## **Appendix B: Air Quality Response**

**RE: Response to Submissions for Bulk Recovery Solutions, Ingleburn**

The following outlines additional information and clarification to address the New South Wales (NSW) Environment Protection Authority (EPA) and Department of Planning & Environment (DP&E) submissions relating to the *Air Quality Impact Assessment Bulk Recovery Solutions, Ingleburn* (AQIA) (**Todoroski Air Sciences, 2018**).

SITE03

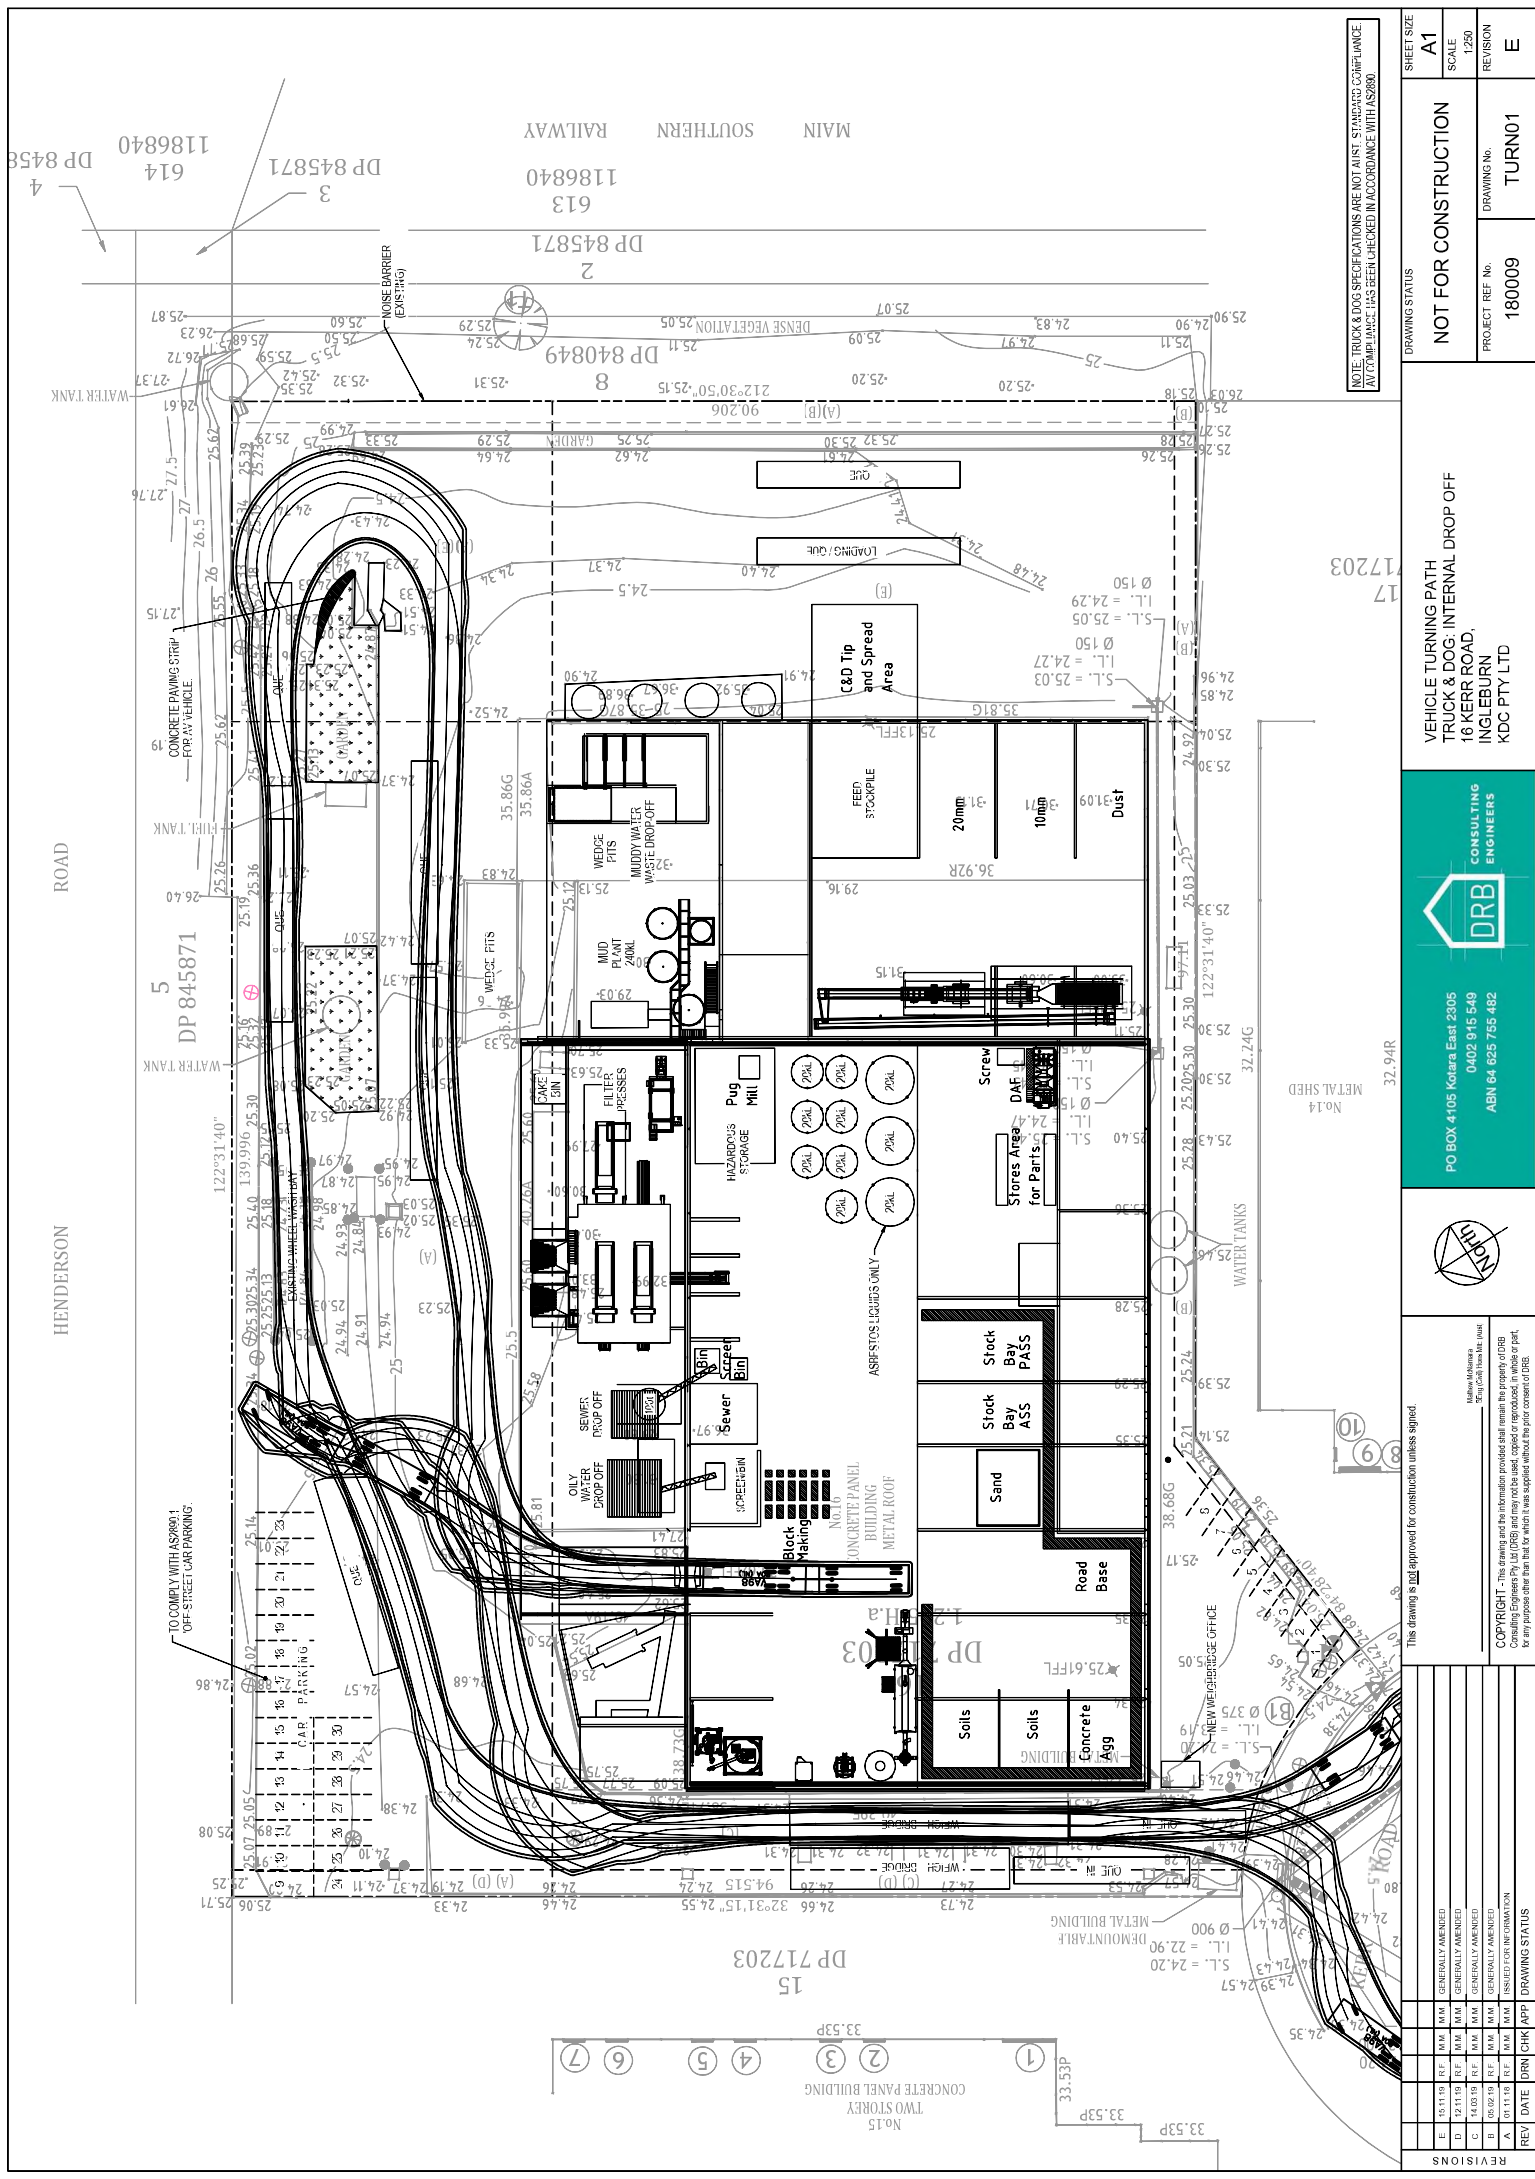
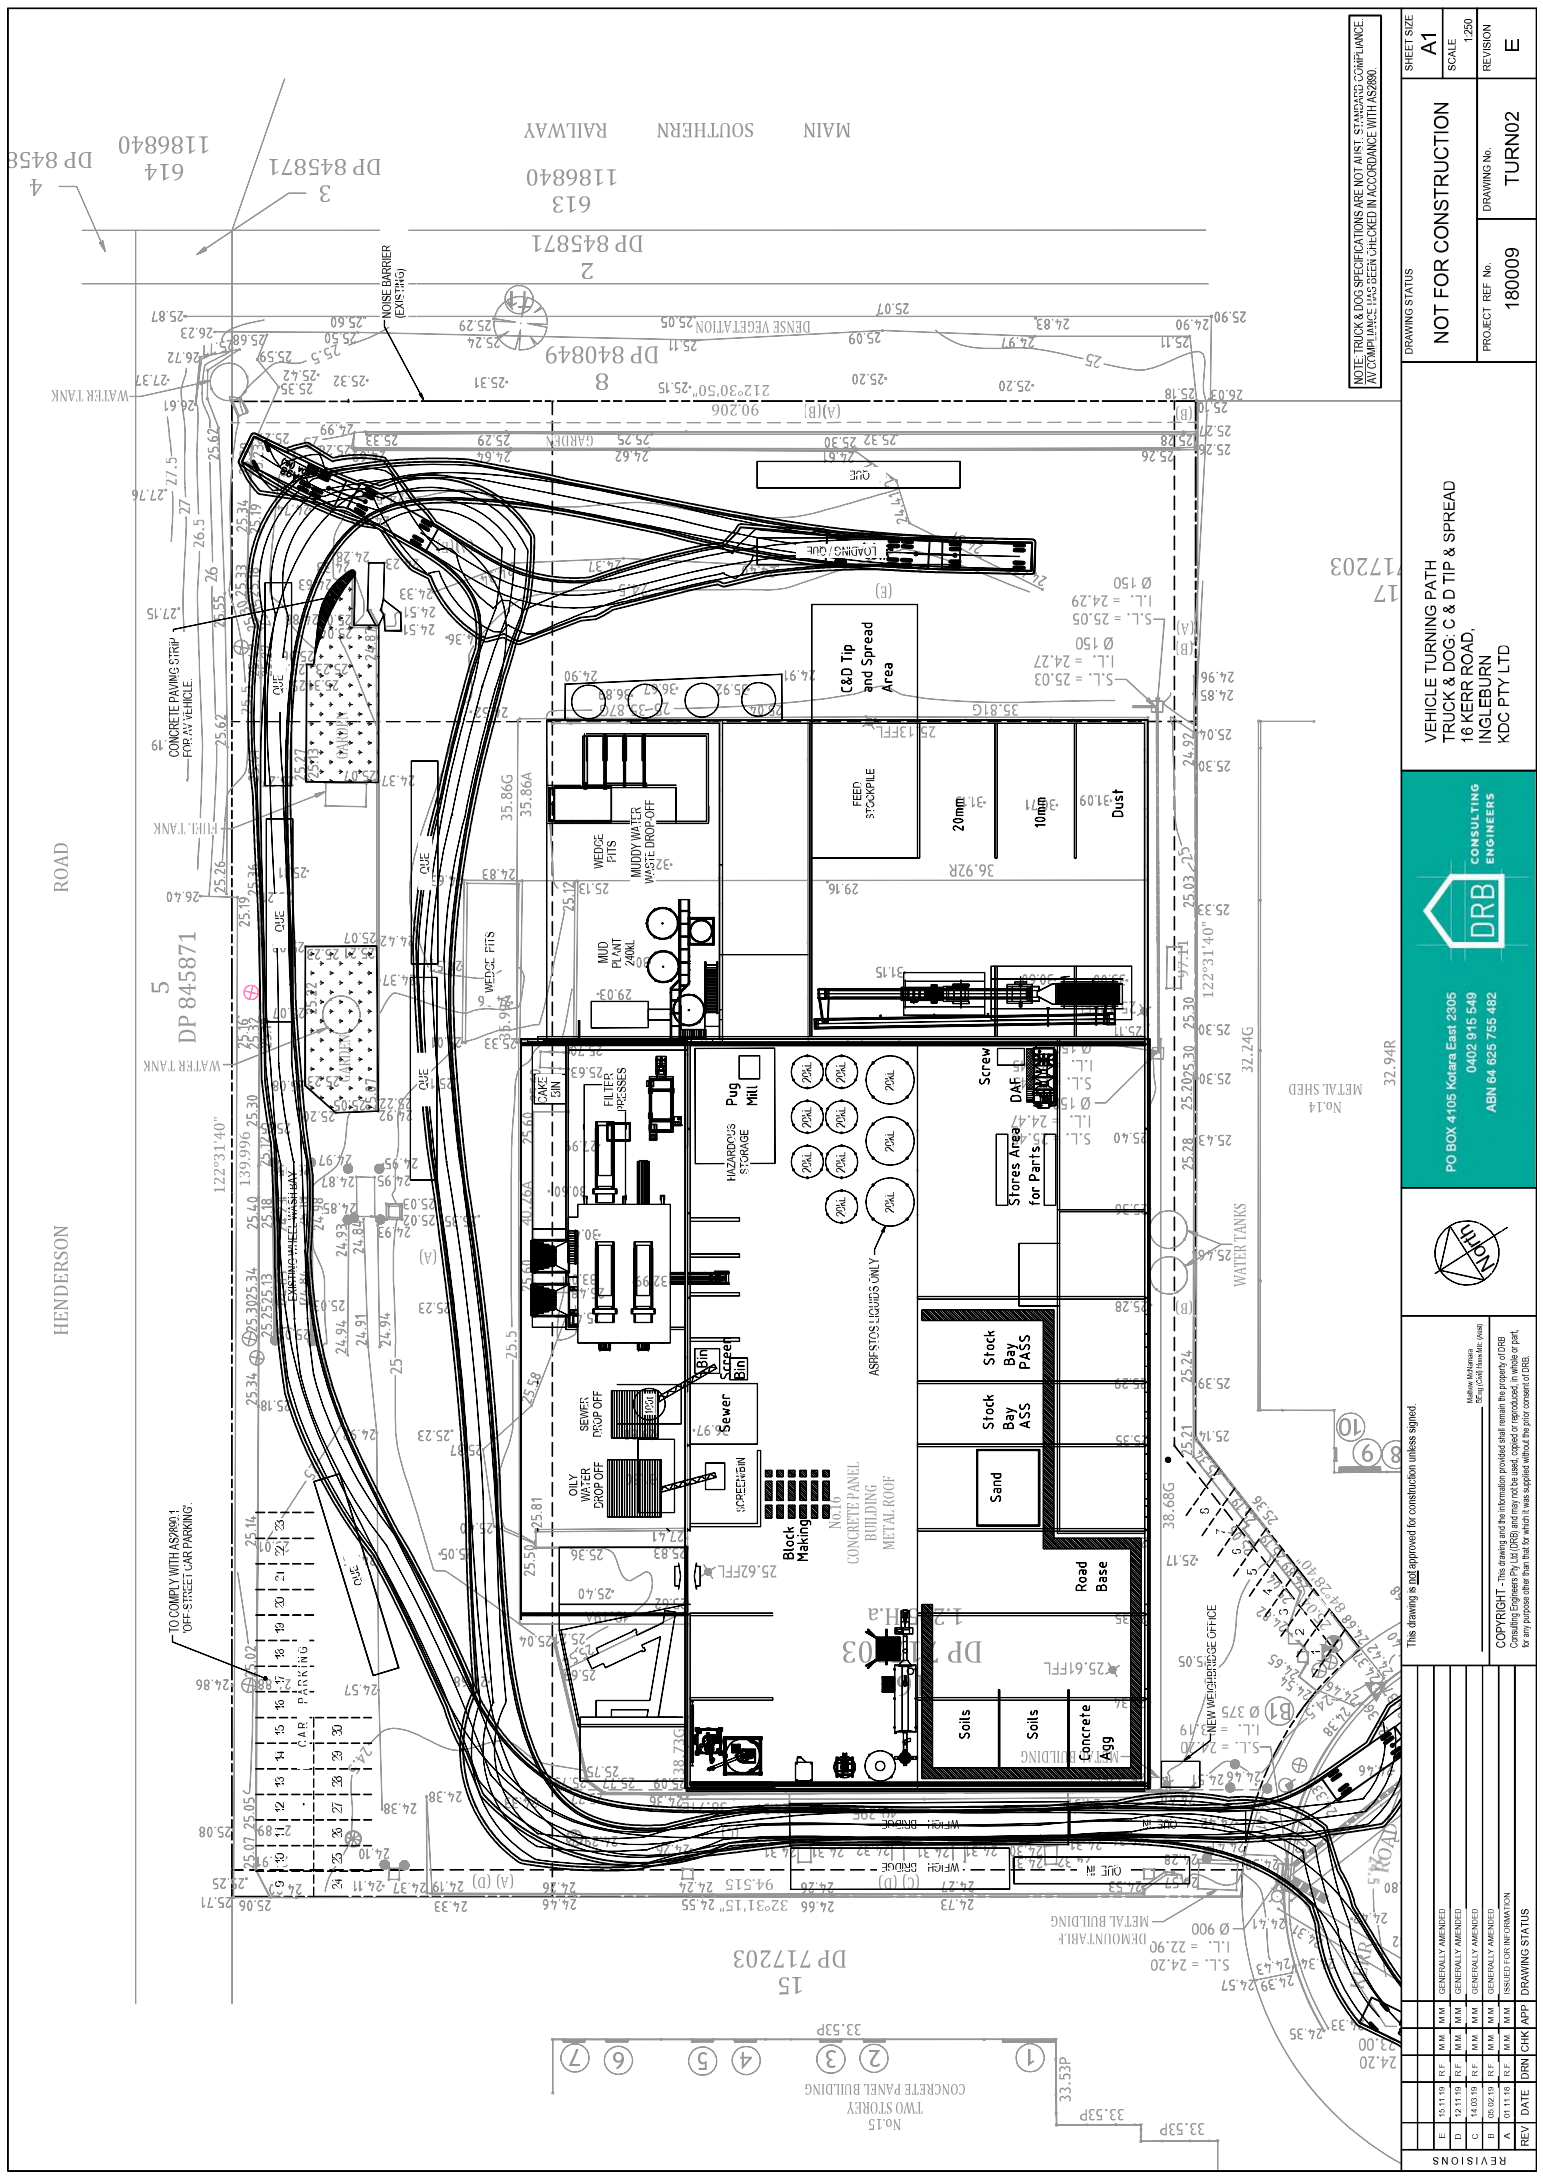
*The solid waste processing at the project involves the crushing, screening and blending of materials to generate desired products. It is proposed that solid waste processing and raw material stockpiling is to occur within an enclosed space with water misting sprays applied to suppress dust within the building.*

*Only finished products are proposed to be stockpiled in outdoor areas in external storage bays. Water will be used to mitigate dust emissions and minimise wind generated dust emissions from this source.*

*Stockpiling of waste and processed material will occur on the south eastern area of the building in designated bays. It is intended that trucks will tip waste at the 'receiving area' for distribution by front end loader to the stockpile bays. Smaller stockpile areas are located internally at the crushing plant and undercover at the screening plant.*

*Waste material arriving and being processed on site will comprise of a variety of waste types including building and demolition waste, foundry sand, reclaimed asphalt, hazardous soils, slag and fly ash. These waste types may contain non-trivial levels of contaminants materials including but not limited to Type 1 and Type 2 Substances (metals). However, the assessment has only considered dust emissions from the premises.*

*The AQIA should consider the potential for any air pollutants likely to be emitted from the various materials that will be delivered, stored and processed at the facility.*

The Project was revised after completion of the AQIA, and reflects the AQIA. The changes to the Project include:

- ✦ No external waste stockpiles in the south eastern corner of the site;
- ✦ New internal stockpiles in north western corner of building to accommodate the waste material that would have been stockpiled in the south eastern corner; and,
- ✦ A revised storage capacity from 30,000 tonnes (t) to 15,000t at any one time on-site across all waste types.

A revised site layout is shown in **Figure 2**.

The waste material including foundry sand, hazardous soils, slag and fly ash received at the project would be stockpiled internally. The material would be sufficiently wetted to ensure minimal dust emissions and hence minimal emissions of other contaminants to arise during the handling and processing of this material. The main processing activity for these types of material would be blending with other materials and then storage in the Concrete Batching Plant silos. For hazardous soils, the material would be stockpiled for the less than 24-hours before being processed.

Furthermore, as all of the handling and processing of this material would occur within the building enclosure, there would be no wind effects to act on the handling and stockpiling of material. It can be expected that this would further control any potential air emissions from this material by up to 70-80% and with sufficient moisture in the material, dust emissions from this would be negligible and any other emissions associated with the dust would be trivial.
